**From:** [Kendal](#)  
**To:** [A585 Windy Harbour to Skippool](#)  
**Cc:** [Edward Clarke](#)  
**Subject:** A585 Windy Harbour to Skippool - Our Client Mrs M Smith  
**Date:** 03 October 2019 12:34:34

We refer to the above and a request in respect of confirmation of notification of acquisition of permanent rights. We write to confirm that the information we have received from Highways England simply confirms that there will be acquisition of permanent rights for various utilities and or Highways England as follows.

Drawing Title ENVIRONMENTAL MASTERPLAN  
SHEET 9 OF 32

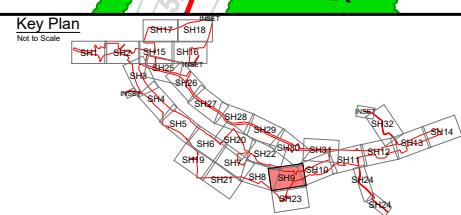
We also note from the Environmental Master Plan sheet 9 of 32 that the land lying to the north of the proposed bypass which will be retained by our clients has an extremely restricted and I would suggest probably unusable access. This access needs to be of suitable hard core construction with dropped kerb to Lodge ane (If it kerbed at this point) so that our clients can

get in and out of the field at this new access point. It is also in an area where there appears to be Woodland Edge planting out with the acquisition area and to which we wish to object.
